From: Planning
Subject: FW: Planning application 3/2025/0801 Land East of Salesbury View, Wilpshire

I note that updated documents have been uploaded to the portal for application 3/2025/0801, Land East of Salesbury View, Wilpshire, following the formal consultation period. These include amended house type plans, schematic drainage layouts, schematic finished levels sheets, updated LVIA, longitudinal/section plans, and proposed storey height plans.

SPLIT LEVEL RETAINING STRUCTURE RECOMMENDATIONS

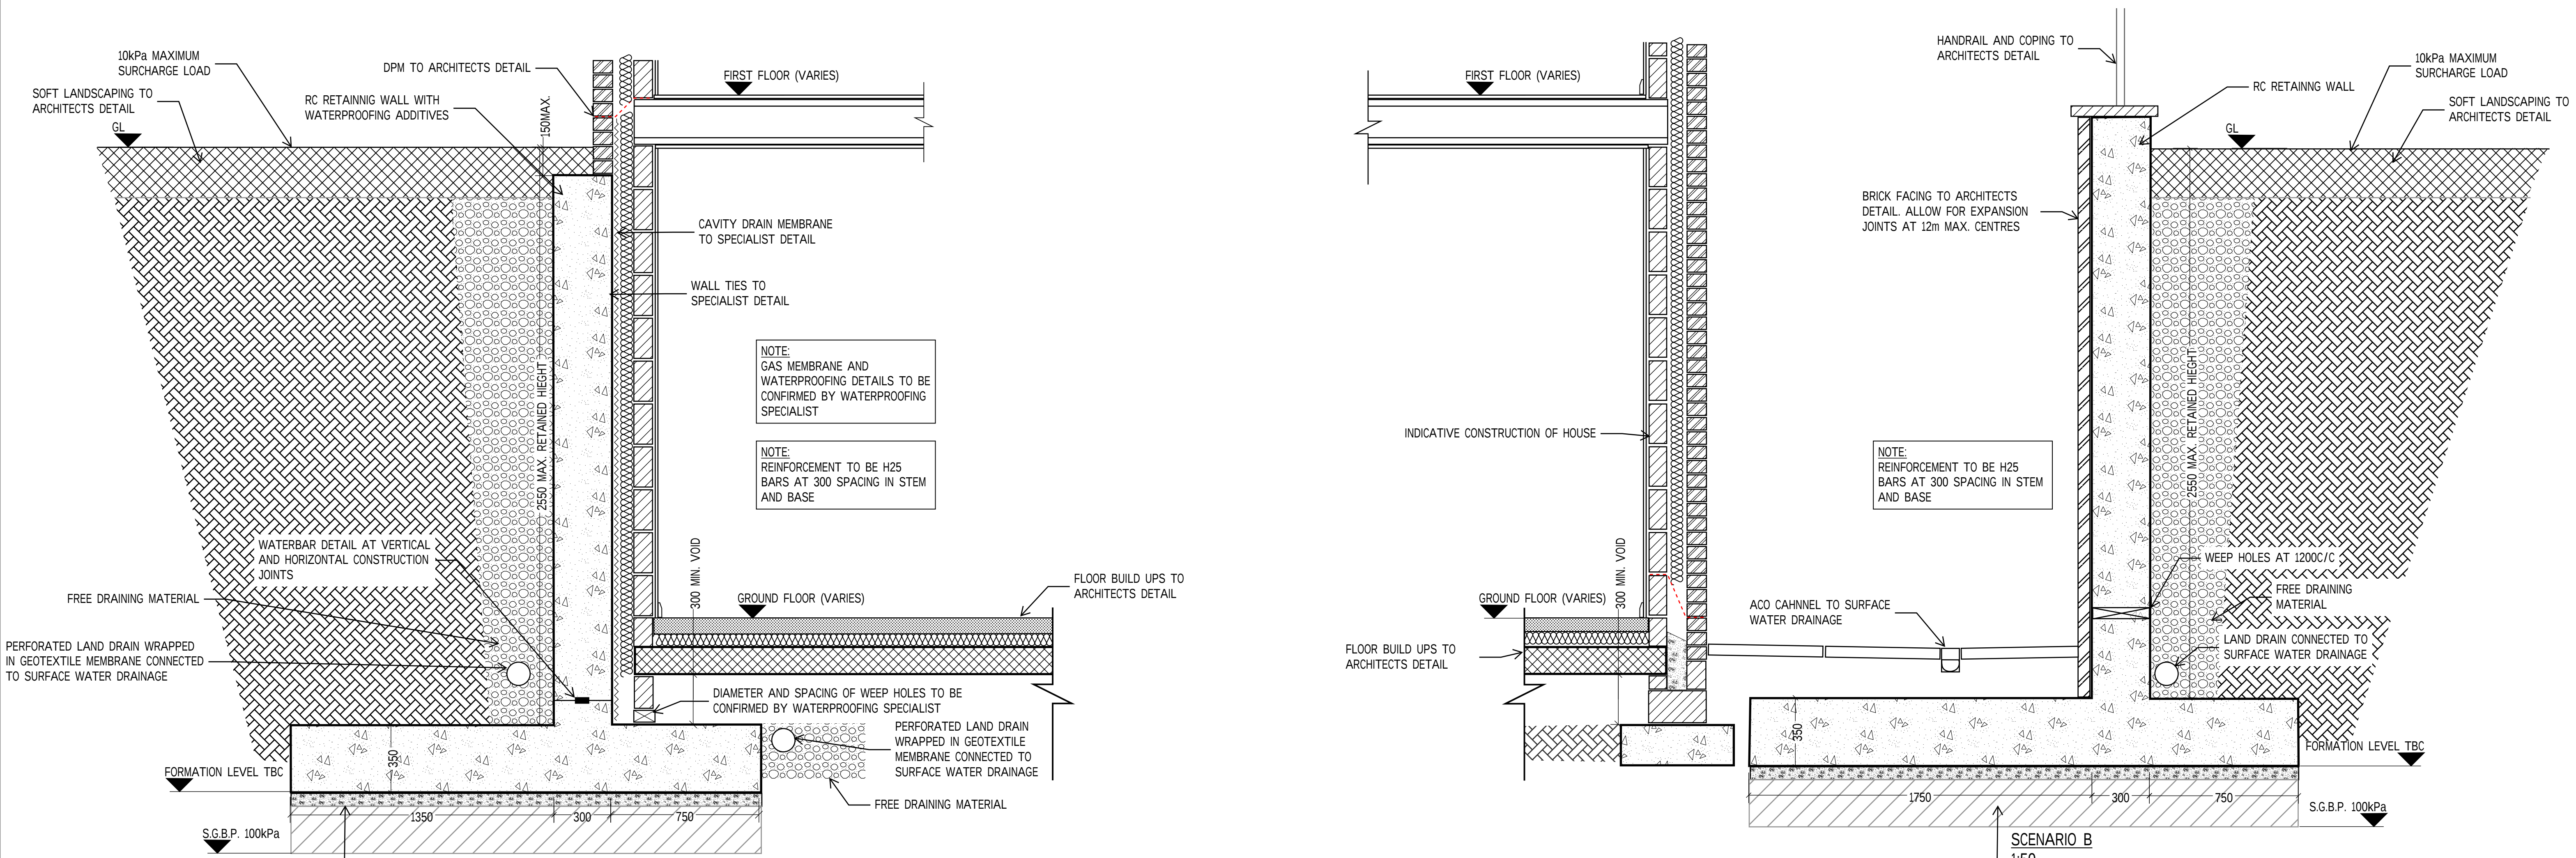
- Detailed cross-sections relative to neighbouring properties remain absent, preventing proper assessment of visual, massing, and slope impacts.
- Structural and retaining wall details, earthworks method statements, and fully annotated topographical plans are still missing.
- Drainage plans remain schematic and unverified against site topography.
- The LVIA continues to rely on long-term tree growth (15 years) as mitigation, which does not adequately address immediate landscape and visual harm.
